From: Jean Fraser
To: Swett, Lauren
CC: Roncarati, Doug; Tarling, Jeff
Date: 2/24/2014 2:07 PM
Subject: RE: Rockland Ave Outfall

C-201

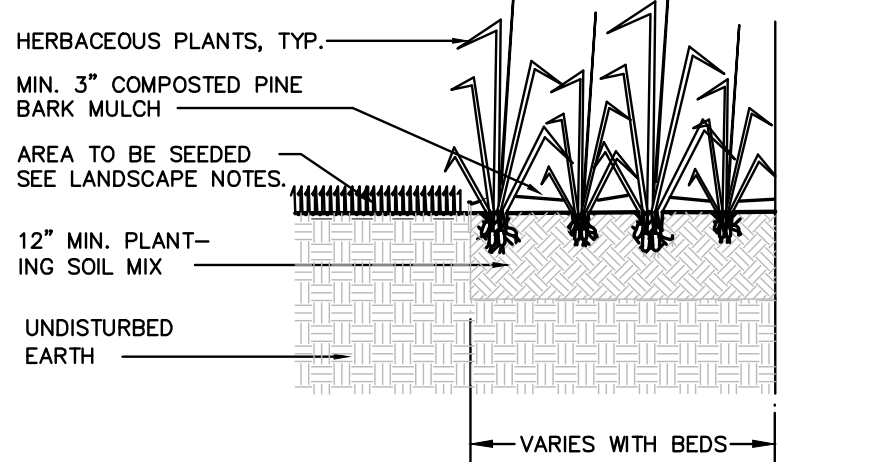
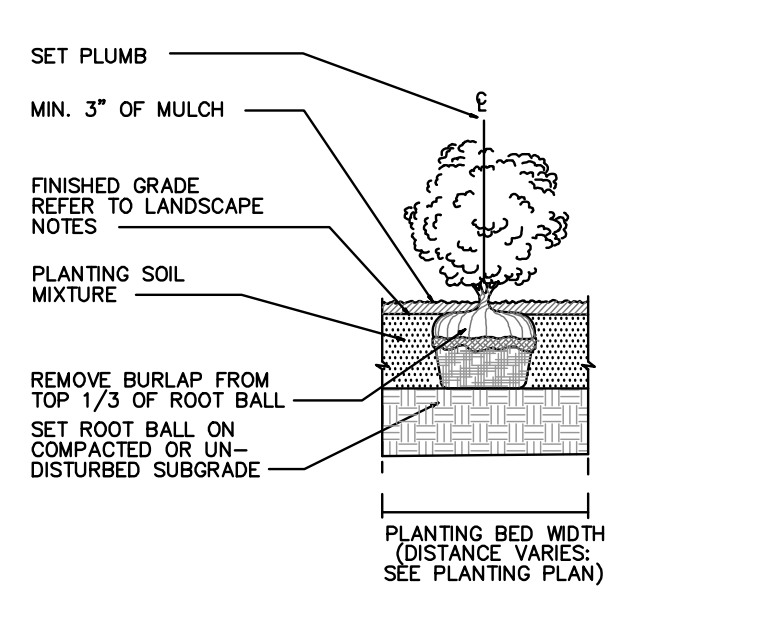
This is not your issue, but the RTI info is not great and still being reviewed by DPS and therefore I would like to be sure that the neighbors and Portland Trails are on board, and have a final proposals plan (referenced in the approval letter) showing the surface/landscape (final location of Portland Trail and paved/graveled areas) that clearly shows the minimal nature of the changes in the area not covered by the Landscape Plan.

For the plans you attached, sheet C-201 is the landscaping plan. The rendering pdf was a visual representation created for use at some of the public meetings, and is not intended to serve as an official landscaping plan.

PS There are two different Landscape Plans (see attached) - which is final and which has Jeff has approved?

temporary location during construction? Why isn't there any landscaping shown where the wider paved area is being introduced (where does not exist now) in close proximity to homes and the trail? Although I am waiting for Jeff to confirm his comments on the proposals, I would like either another site plan or the landscape plan to show just the final condition, with the trail shown and labeled and what is happening (landscape wise) around the new maintenance access and treatment unit (I know its underground but there will be disturbance and round man made features showing above ground I believe.)

After a closer review of underground utilities, stormwater and sewer mains along with unexcepted street information, the landscape plan is acceptable as shown for the Rockland Avenue / Capsic Pond project. (we don't have the room or easement to plant additional landscape in the area we discussed)

PLAN NUMBER
 C-301

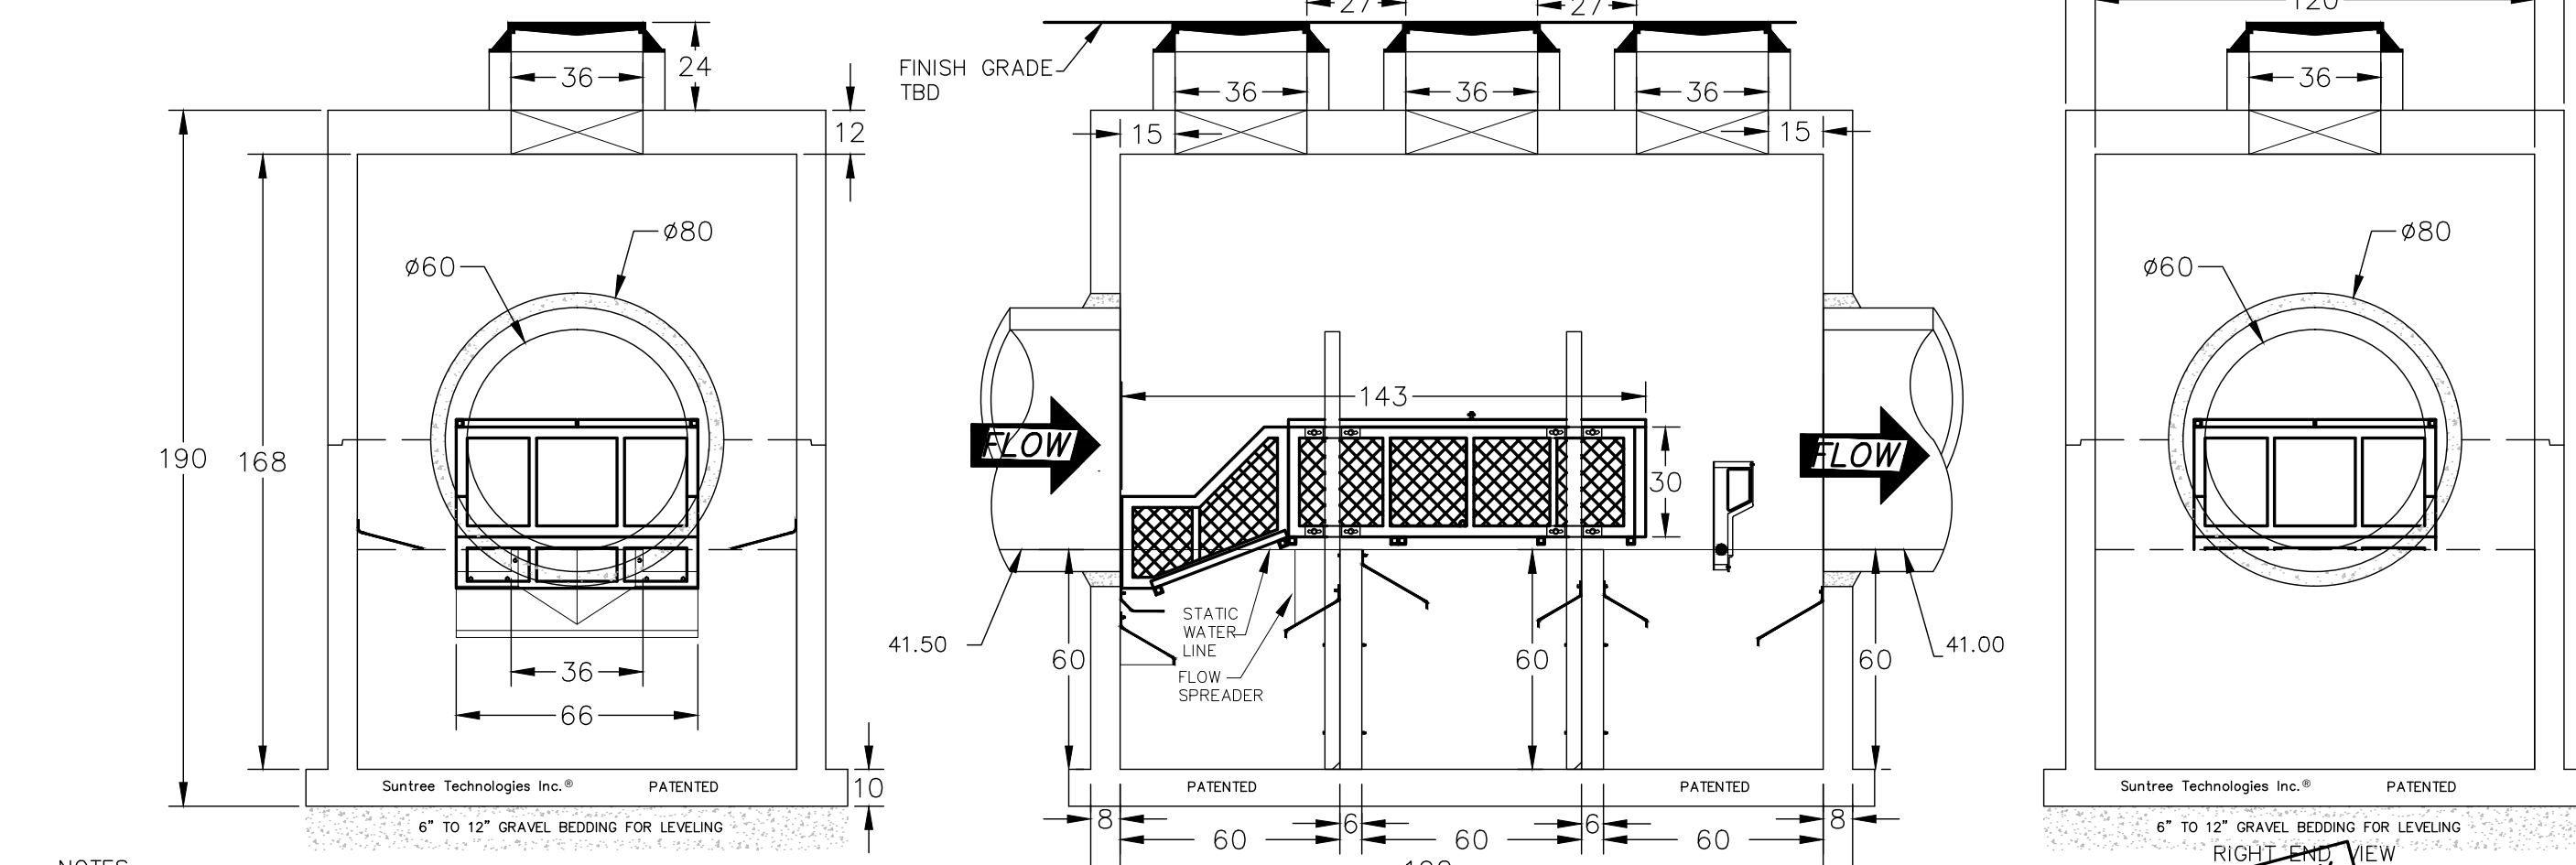
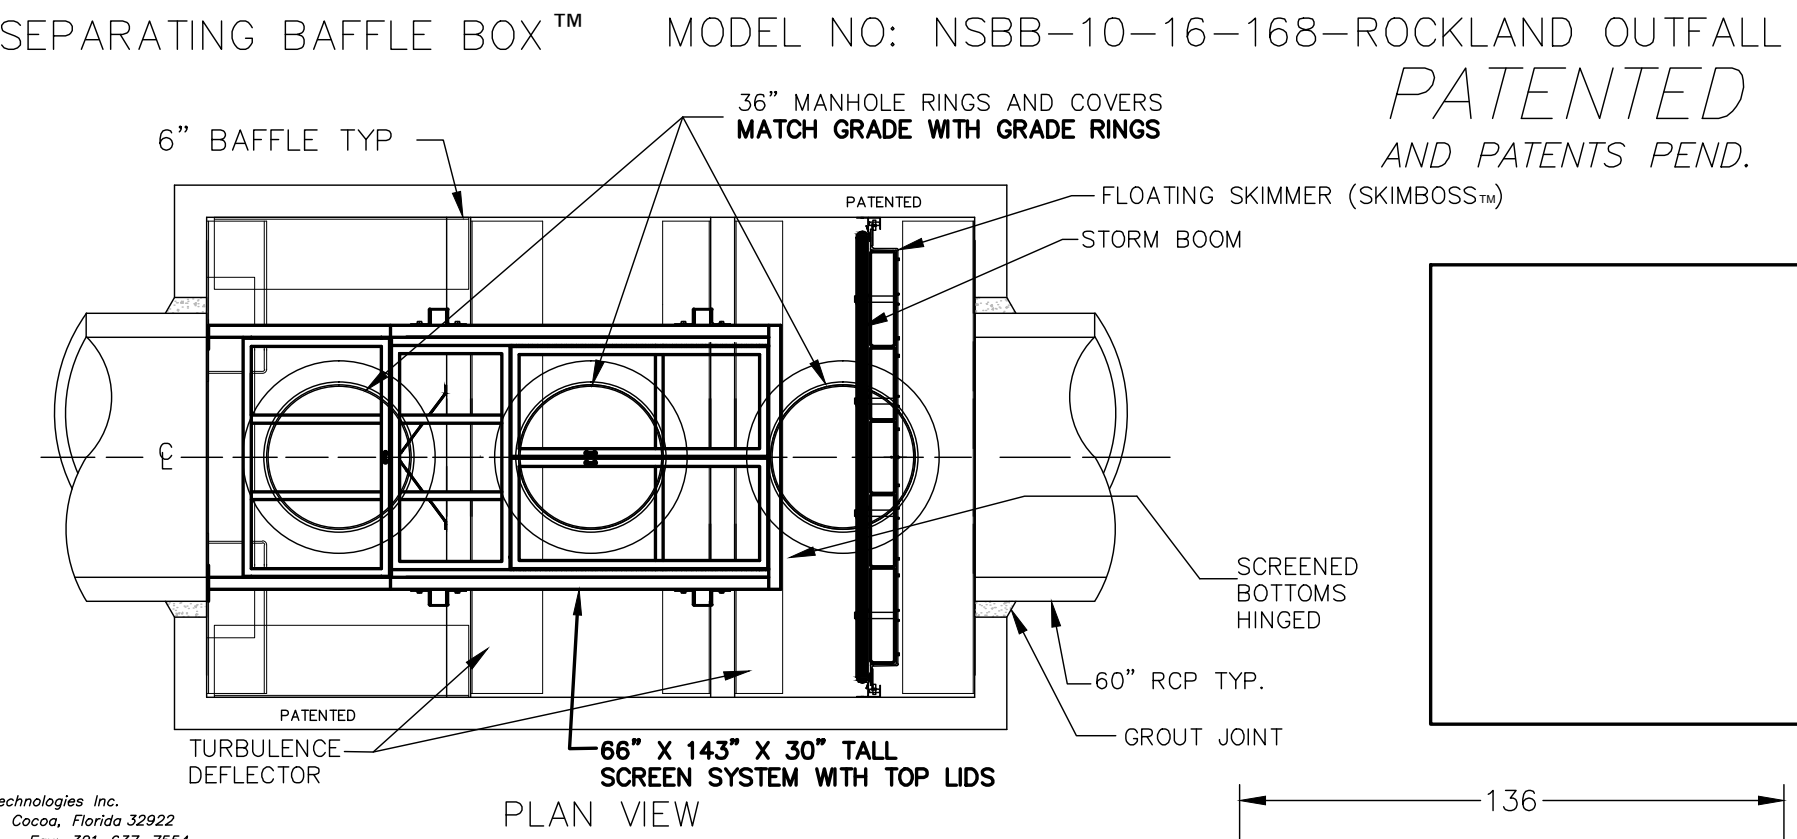
A few things have come up where further information would be helpful:
Section 3 of the application booklet, RTI- is there an updated "boundary page" (as mentioned); Since the access is going to be permanently upgraded, is some kind of easement or permission from abutters needed- the City's land is very close to the existing house and I would have thought there would be some restrictions on use of the land (DPS may have documentation so have copied Doug) The site plan is confusing as it shows existing, interim (temporary) and final all on one plan- so raises questions: Presumably the reinforced maintenance access is permanent, so where will the trail be after its

We are creating a figure to clearly show the proposed conditions at the site to help address your original questions about the site plan. We can show more clearly what the reinforced maintenance access way will look like on the plan. Per the detail on sheet C-301, there will be 3' strips of gravel wearing course, with loam and seed to surround those gravel areas. The intent is not for the maintenance access to be overly intrusive. There will be a gravel subgrade beneath the gravel strips and the loam and seed so that trucks can drive over the area to access the stormwater treatment unit.
